**Consultation Response from KC,  
Highways Development Management**

**2024/92768 land rear of, 23, Dalton Fold Road, Dalton, Huddersfield, HD5 9NL**

**Outline application for one detached single storey annex dwelling at, land to rear of 23 Dalton Fold Road, Dalton, Huddersfield, HD5 9NL**

**Date Responded: 16-1-2025.**

Site Block Plan as Proposed

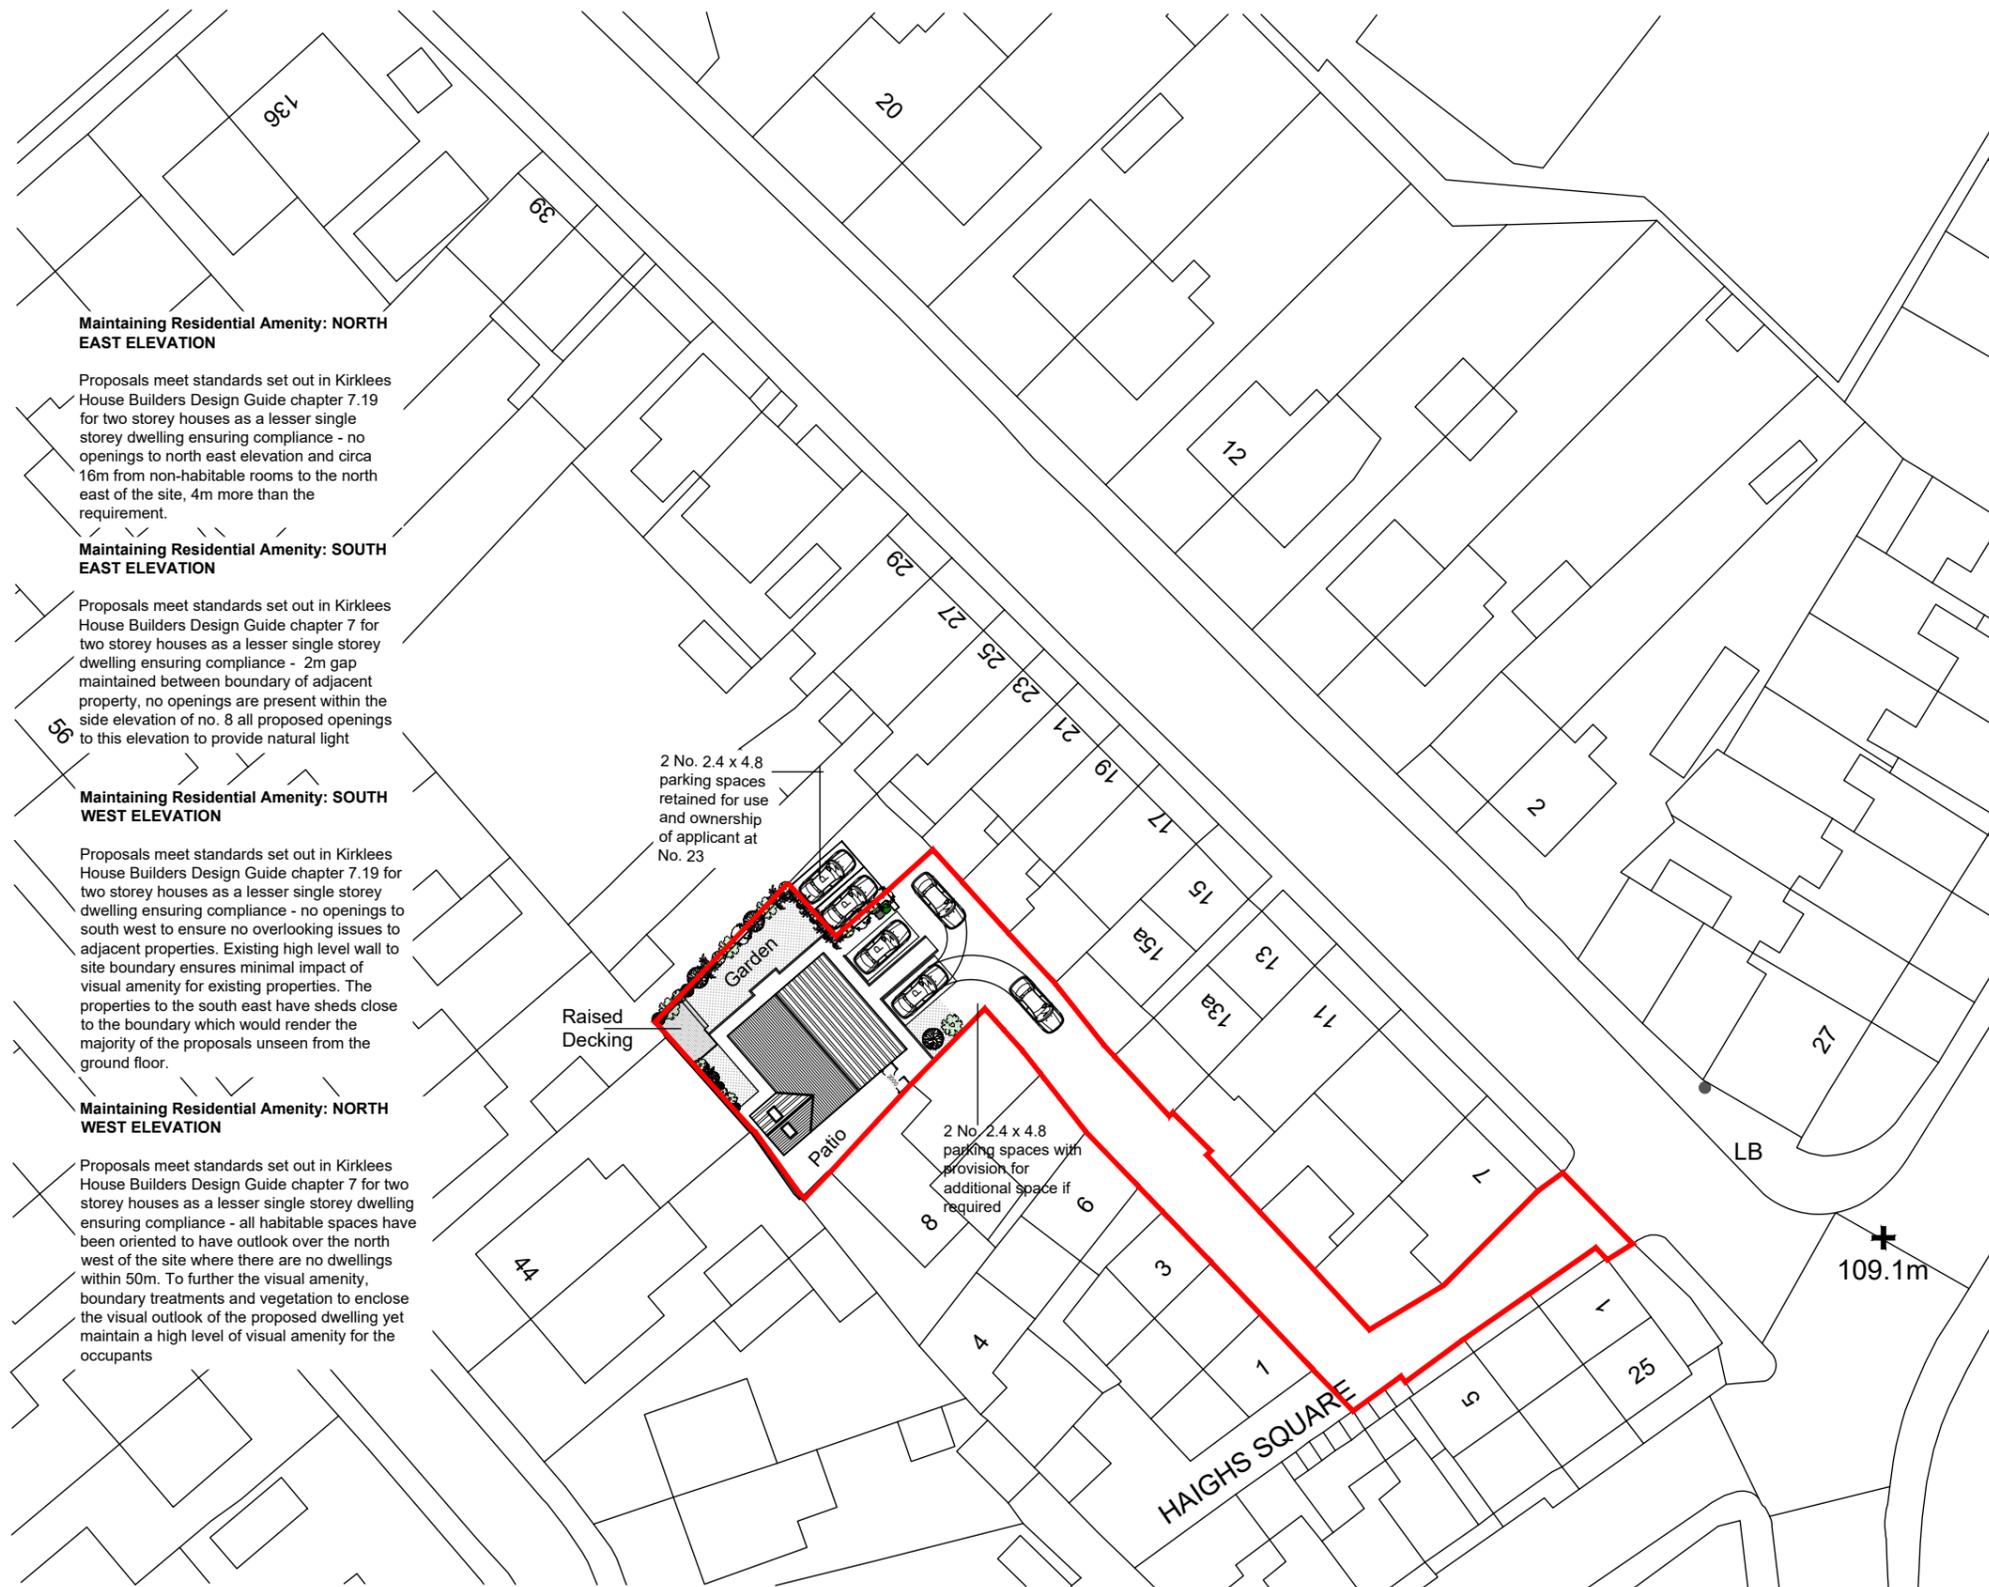
*1, The existing access track is severely sub-standard being narrow (not wide enough for 2 vehicles to pass), un-made, there are also no footways, drainage or street lighting and there is no turning head.*

*2, Emergency Access should be as follows: There should be a minimum carriageway width of 3.7 m between kerbs. There should be vehicle access for a pump appliance within 45 m of single-family houses. Turning facilities should be provided on cul-de-sac roads/driveways exceeding 20m in length. In this case the access track is more than 45m in length and there are no fire tender turning facilities.*

*3, Waste collection. There is no access or turning facilities for a refuse vehicle and the bin presentation point would therefore have to be at the junction with Dalton Fold Road which is more than the recommended 25m from the storage point.*

The applicants have now revised their proposals to show a 2 bedroomed detached single storey annex dwelling. The access proposals are otherwise unchanged.

Given the access proposals are unchanged HDM still consider that there is no option other than to recommend refusal of this proposal.
